Online Comment

Application H16-0423-18
Location 11 Tower Lane Spalding PE11 2RG
Proposal Replacement dwelling following permission for demolition of existing dwelling

Name Ian Marshman, Historic Environment Officer
Address Lincolnshire County Council Places Team Lancaster House 36 Orchard Street LN1 1XX

Elevation 01 - Front

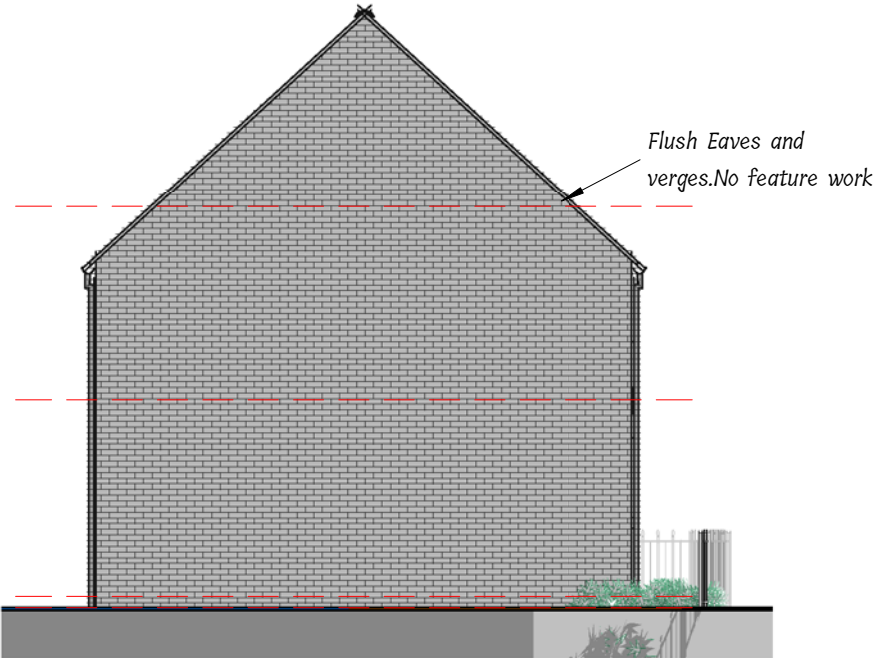
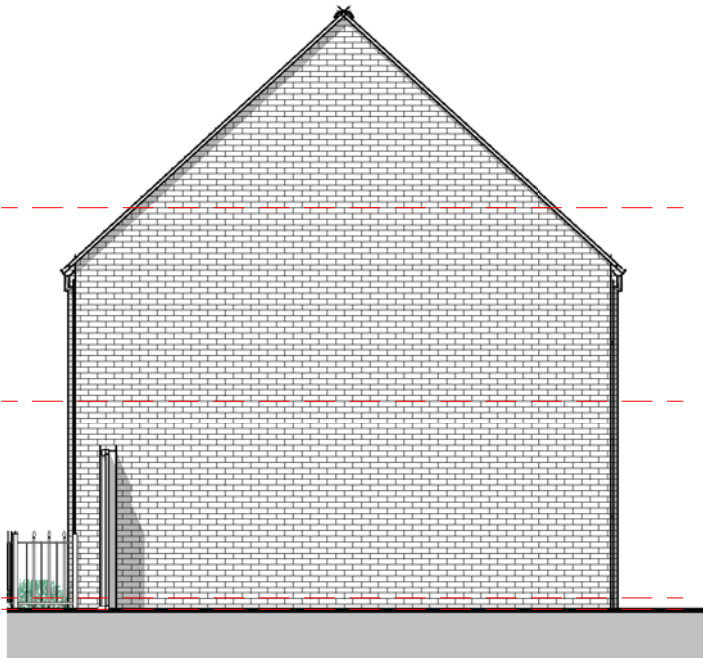
This resulting proposals for new building mixes incongruous elements from different architectural periods and styles without coherence or respect to its sensitive historic surroundings; loosely resembling a converted historic agricultural building with a double height glazed barn door, mock tie-bars mimicking old repairs, modern proportioned windows and lack of detailing, with the iron railings and front garden of a polite Georgian town house. The size of the proposed building also exceeds the footprint of the original house creating a heavy block-like appearance, which is out of keeping with surrounding buildings that have varied roof lines and/or greater visual interest in their facades. Given this, the proposed development would harm the setting of nearby Listed buildings and the surrounding conservation area.

Whilst a replica of the fire-damaged Georgian house might not be desirable, any redevelopment here must enhance the conservation area. This could be as an exemplar of modern design inspired by and sensitive to its surroundings, or in the form of a historic coach house and outbuildings designed with an accurate understanding of the architectural character and detailing of surviving local examples.
